Application No: AB/129/21/HH
Site Address: Fern Cottage 5A Surrey Street Arundel BN18 9DT
Description of works: Loft conversion to habitable use with 1 x rear dormer including the installation of 2 x front conservation rooflights. (This application may affect the character and appearance of the Arundel Conservation Area).

Thank you for your internet representation made on 26th November 2021 which has been recorded as an objection with the comments as follows:

OWPC42201

Existing South Elevation

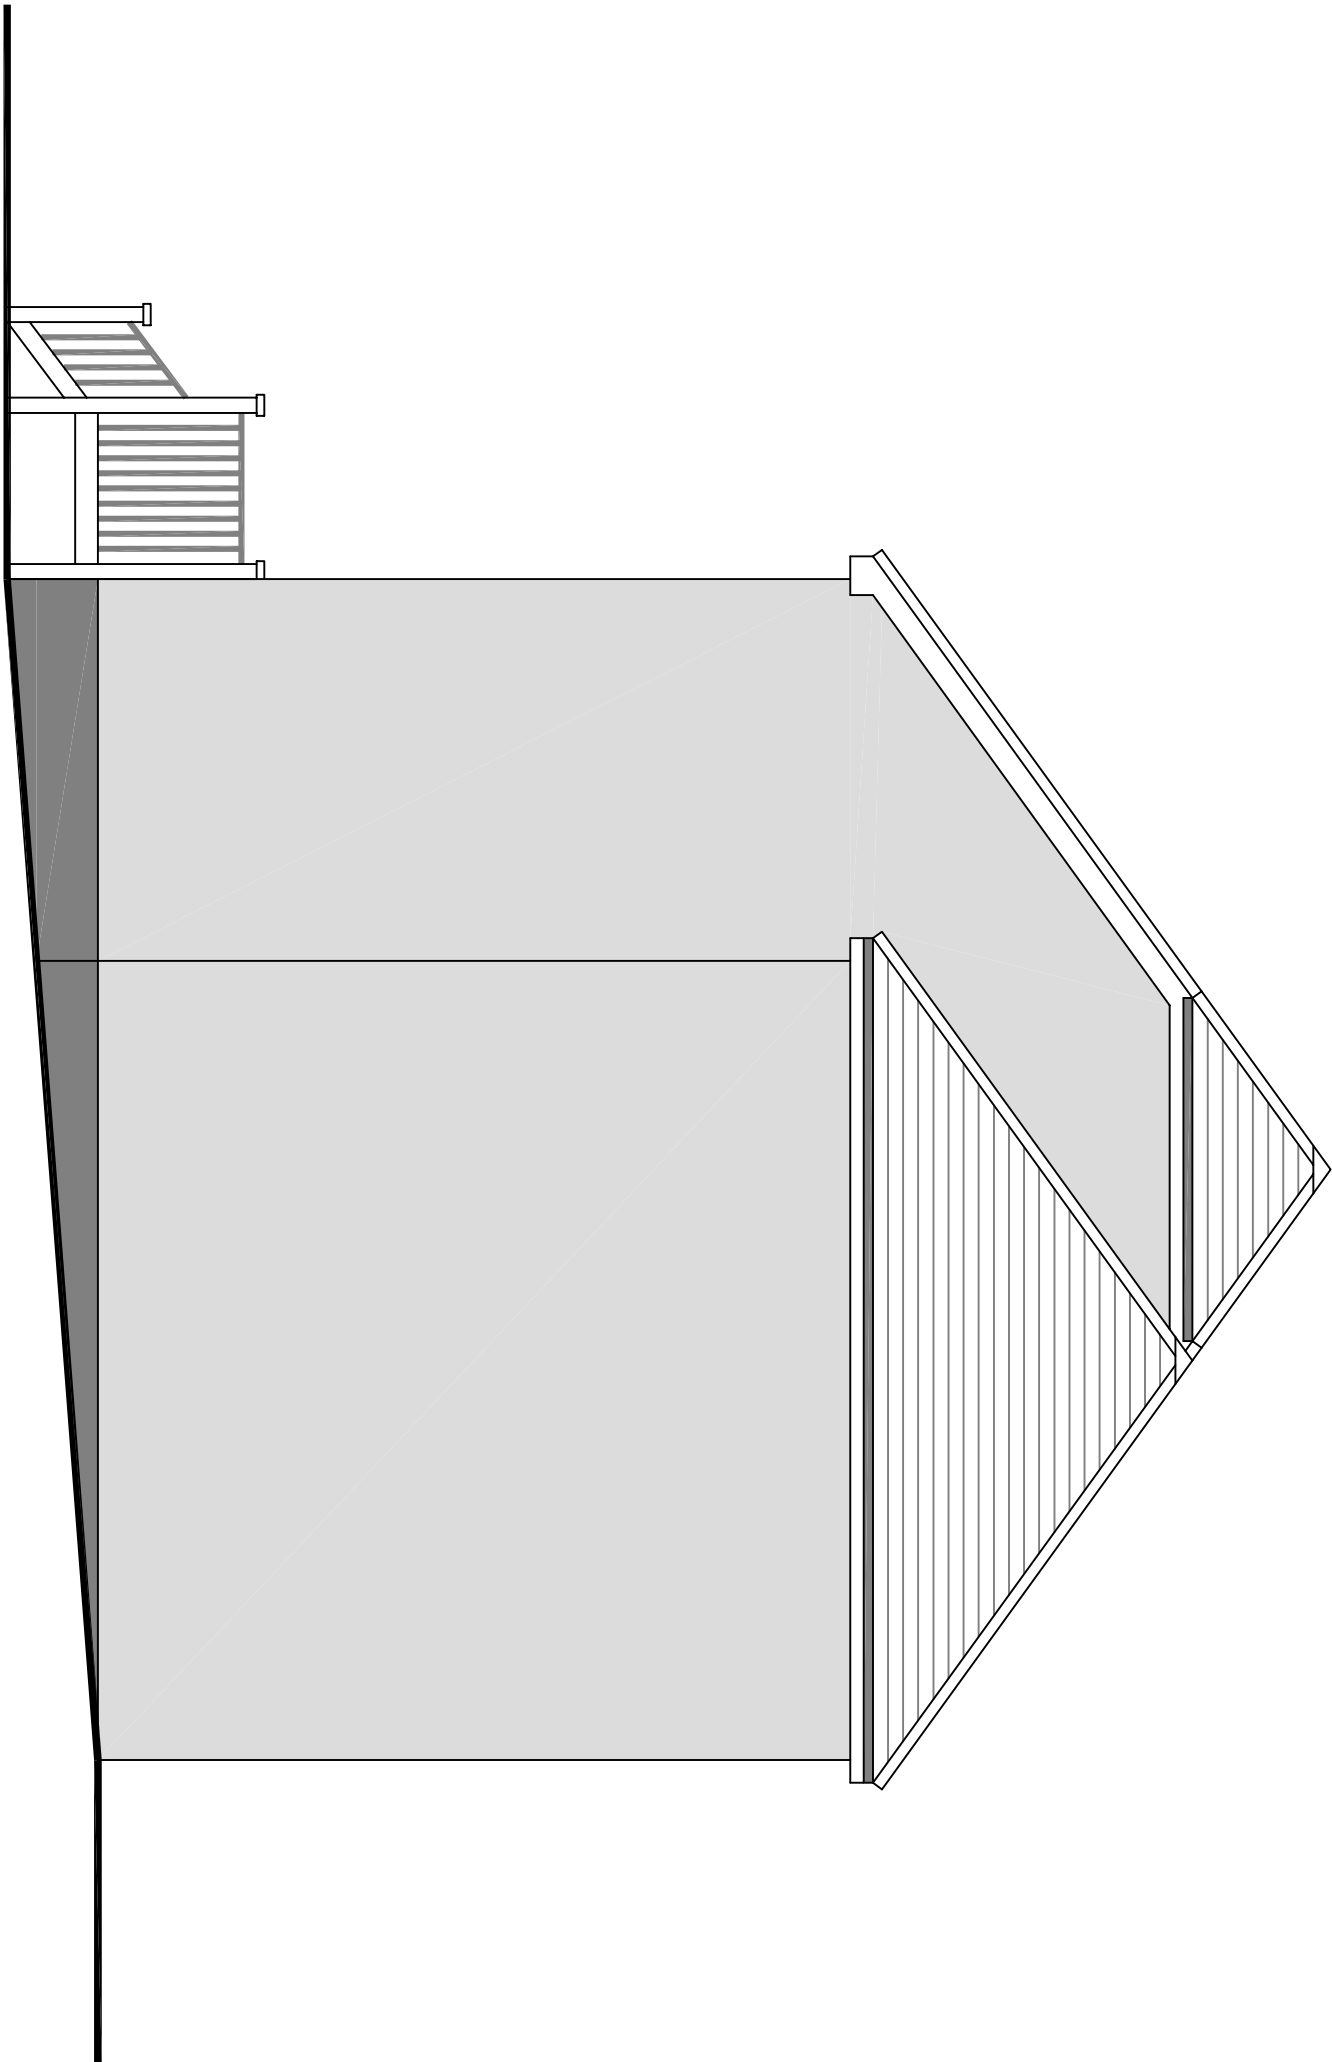
The plain, unaltered, continuous, front roof slopes of 5a-25 Surrey Street are attractive features in the streetscene. In view of this the Panel consider that the introduction of roof lights on the front roofslope of 5a Surrey Street will detract from the building, the setting of the listed terrace beyond and, therefore, also the character and appearance of this part of the conservation area.

If the Council comes to a view that rooflights could be acceptable in principle it is strongly recommended that the exact size and design of them should be established with the agent since, as shown on the drawings, each one appears to be only slightly smaller than the existing window openings which could lead to excessively large rooflights. The central glazing bars are shown horizontal but in a conservation roof light they are invariably vertical. It would be important to ensure that the conservation rooflights include a vertical central glazing bar since they help to reduce the apparent scale of the units. Even modest scaled conservation

rooflight units will need this, given the historic setting.

The existing painted timber vertically sliding sash windows in the building (each of 6 panes over 6) are still not correctly portrayed on the elevational drawings and it is important that if any planning permission should be granted it does not inadvertently convey consent for the replacement of these appropriate windows with inappropriate ones. The existing traditional window design and details are important to the appearance not only of the host building but also that of the conservation area and the immediate setting of the adjoining listed terrace. It is understood that the original planning permissions for the residential development of The Slipe which included 5a Surrey Street had conditions attached which removed permitted development rights in respect of alterations to the buildings. This was clearly undertaken to protect the historic character of the locality. For these reasons it is suggested that it is important for the plans to be amended to show the correct and accurate appearance of the existing fenestration.
